**Consultation Response from KC,
Highways Development Management**

2025/92969 Bamforths Warehouse, Station Road, Holmfirth, HD9 1AB

Date Responded: 27-11-2025.

PROPOSED SITE LAYOUT

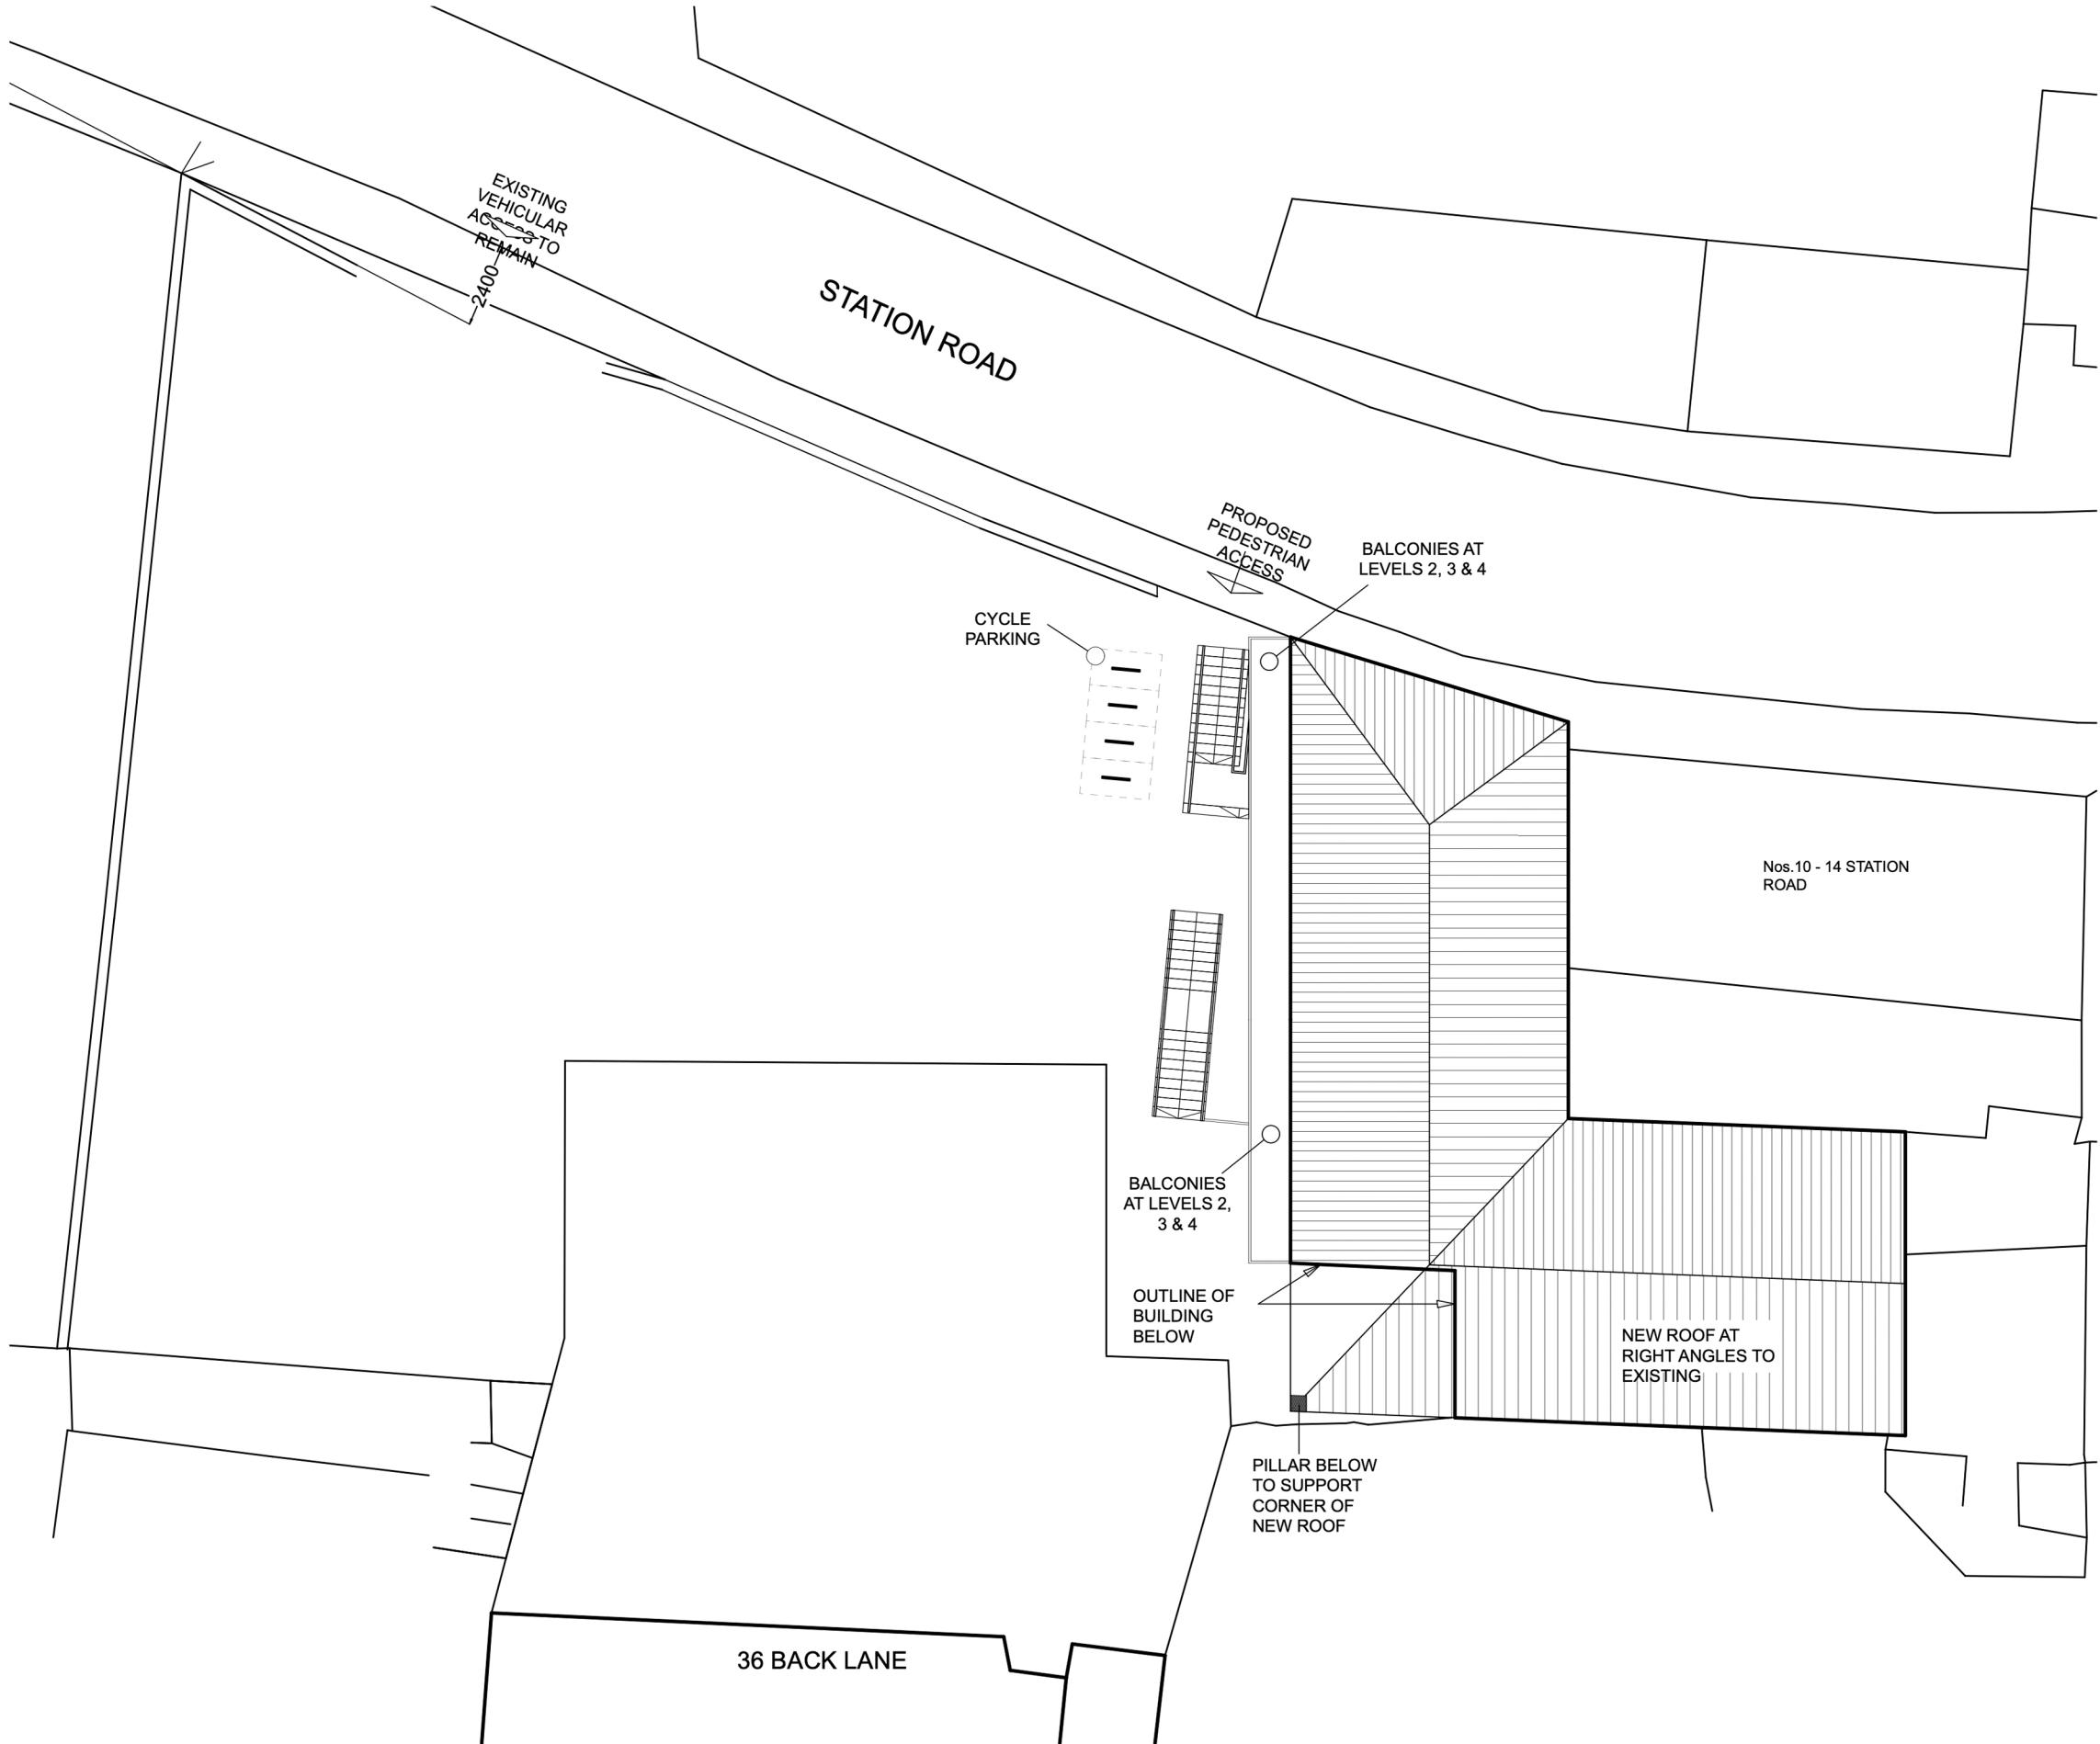
No details of a safe access or disabled access to the flats are provided. Plan 2174(P2)02.1 shows a ground level entrance to stair well and lift shaft from the car park which is no longer shown to be provided on the brewery plans.

Servicing and bin storage for the apartments would have been from the car park. No information is provided regarding the servicing or bin storage.

Whilst it is acknowledged that the proposed flats are in a sustainable location HDM cannot agree to the removal of this condition until acceptable details of safe access, disabled access, bin storage and servicing for the proposed flats are provided.
